Application Ref:	2026/0215				Ribble Valley Borough Council www.ribblevalley.gov.uk
Date Inspected:	09/06/2026	Site Notice:	23/04/2026		
Officer:	EP				
DELEGATED ITEM FILE REPORT:					APPROVAL

Development Description:	Proposed single storey rear extension and front and rear roof dormers.
Site Address/Location:	3 Crowtrees Road Sabden BB7 9HE

Rear South East Elevation 1:100

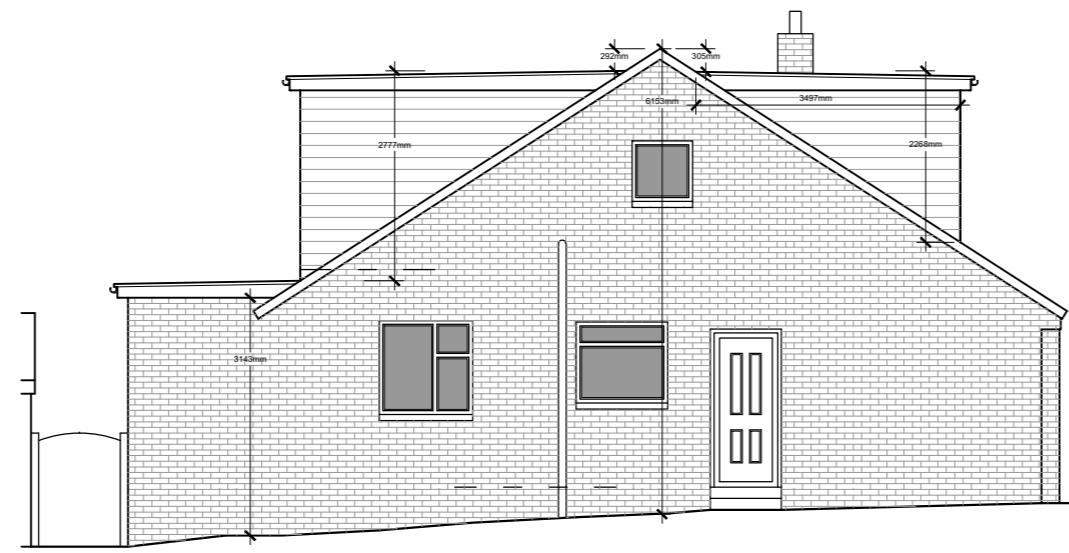
The proposed openings within the rear dormer may provide some opportunity for overlooking into neighbouring curtilage, by virtue of the properties elevated position. However, given the properties elevated position, some degree of overlooking is likely already. The difference in ground levels between the application dwelling and neighbour to the rear is significant. As such, the existing boundary treatment will largely screen the development from view form the neighbouring curtilage. The original scheme did comprise a Juliet balcony within the rear dormer, in the interest of mitigating harm to neighbouring amenity and the perception of overlooking, this has been removed.

Front North West Elevation 1:100

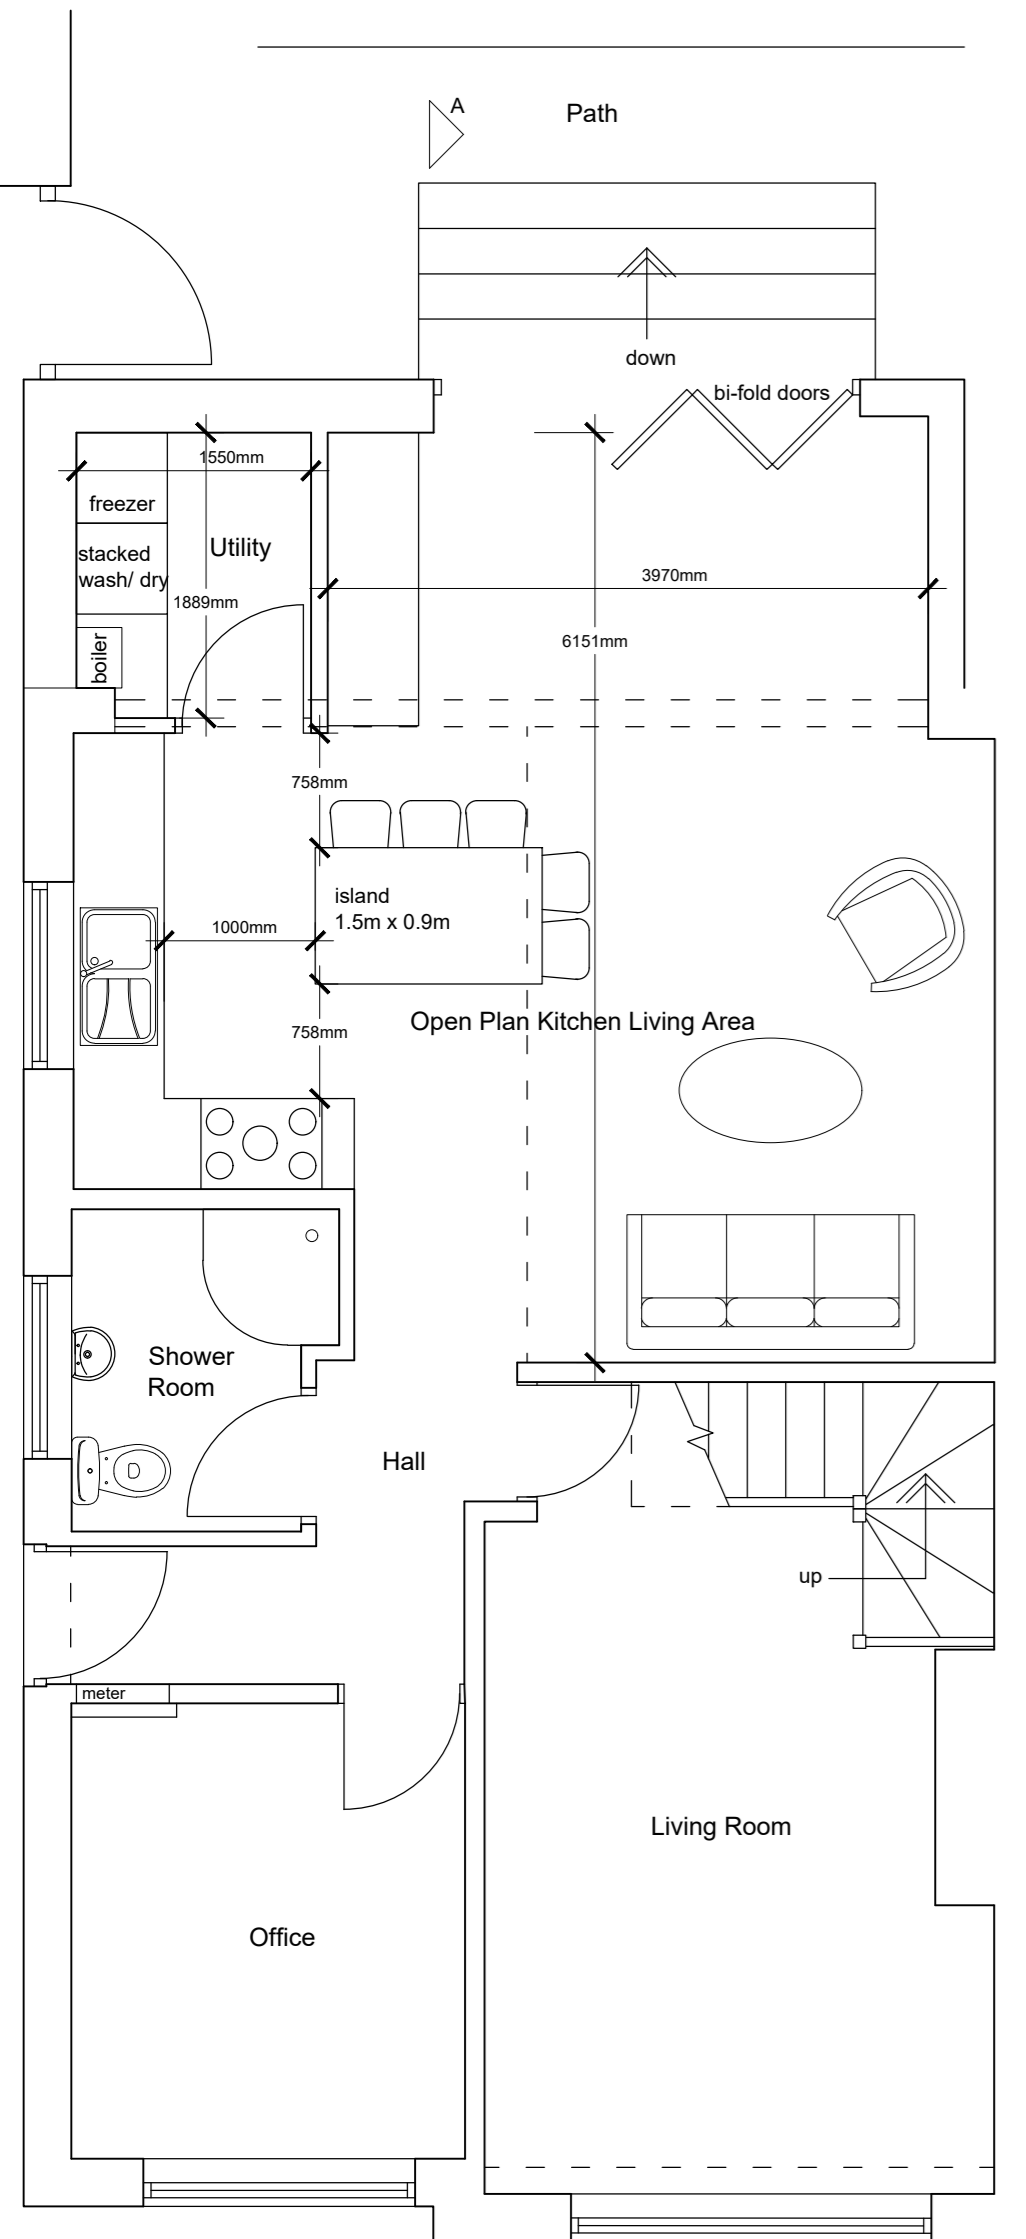
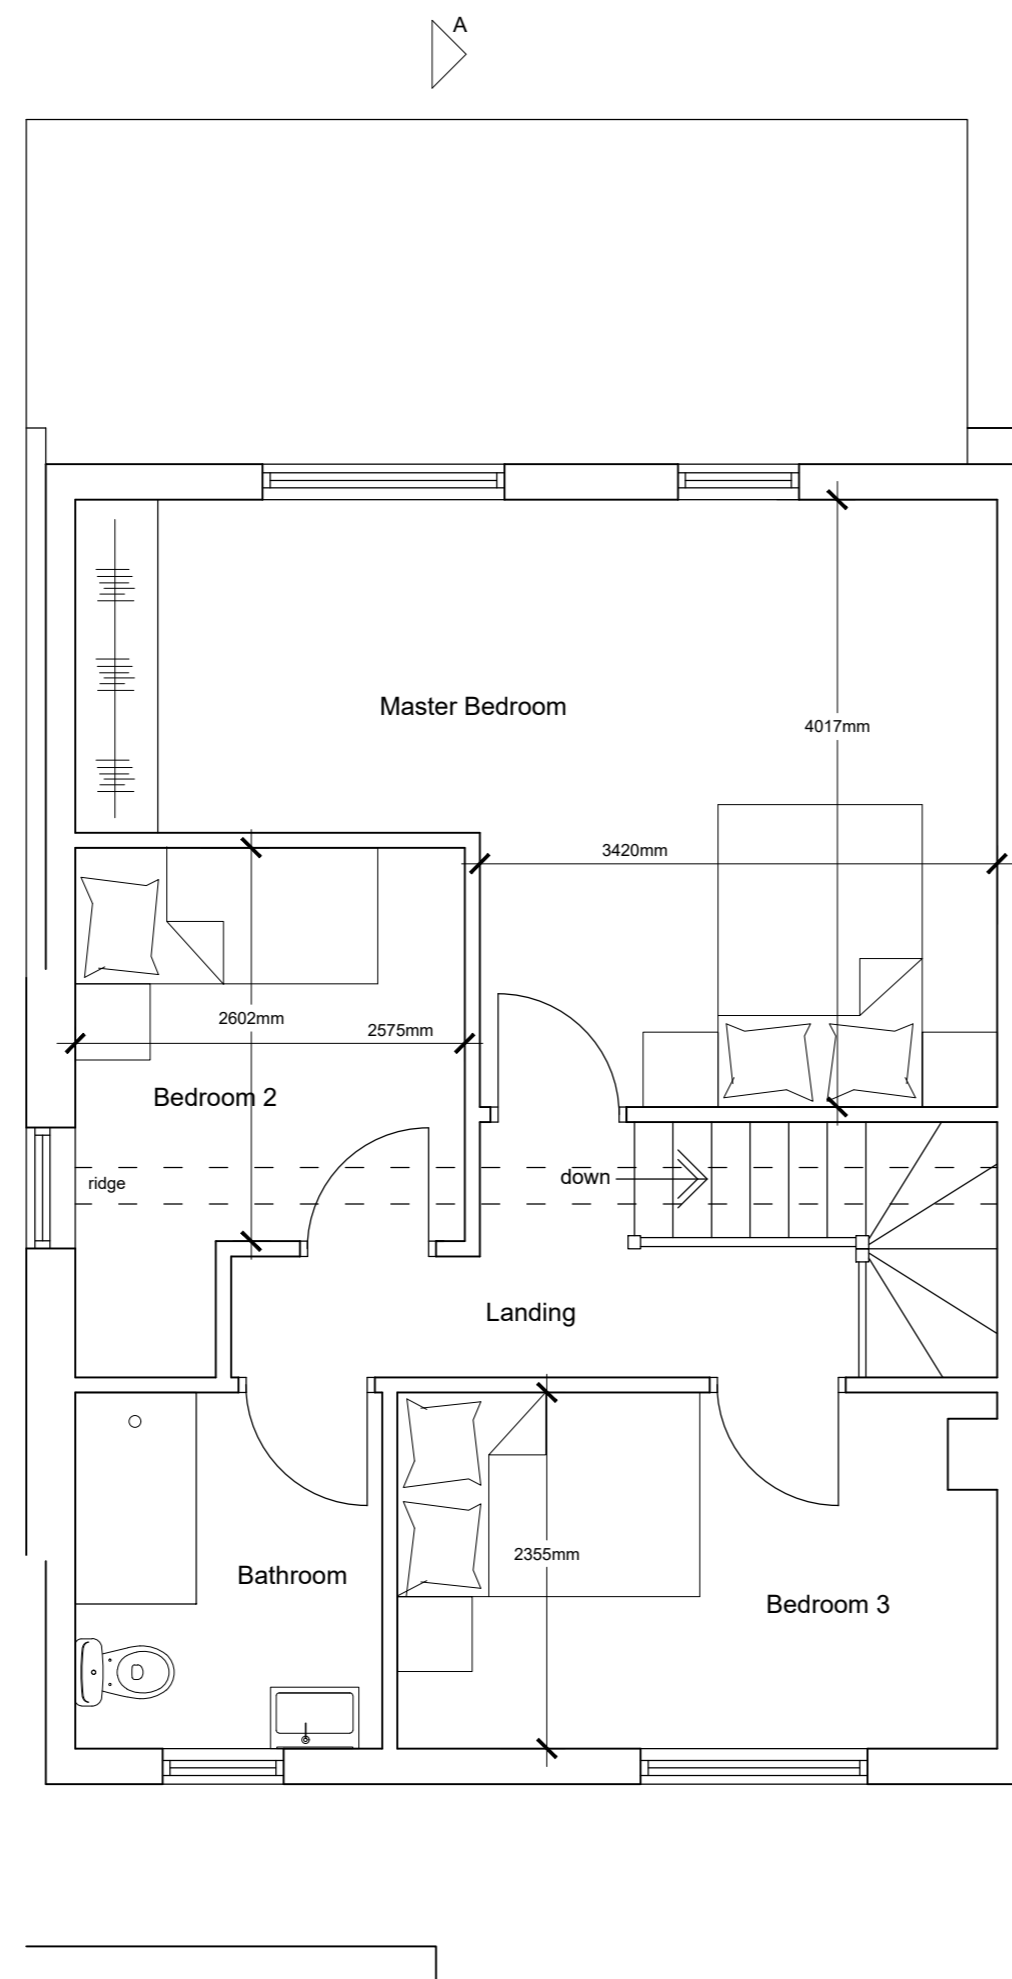
The proposed box dormers would be significant in size, taking up the majority of the front and rear roof slopes of the dwellinghouse. Albeit the proposed front dormer is smaller in scale than the proposed rear, both dormers will be set up from the eaves of the dwelling and below the ridge of the existing roof.

The openings proposed to the front dormer would not have a direct interface with any neighbouring habitable room windows. As such, no new opportunities for direct overlooking or loss of privacy are anticipated in this respect.
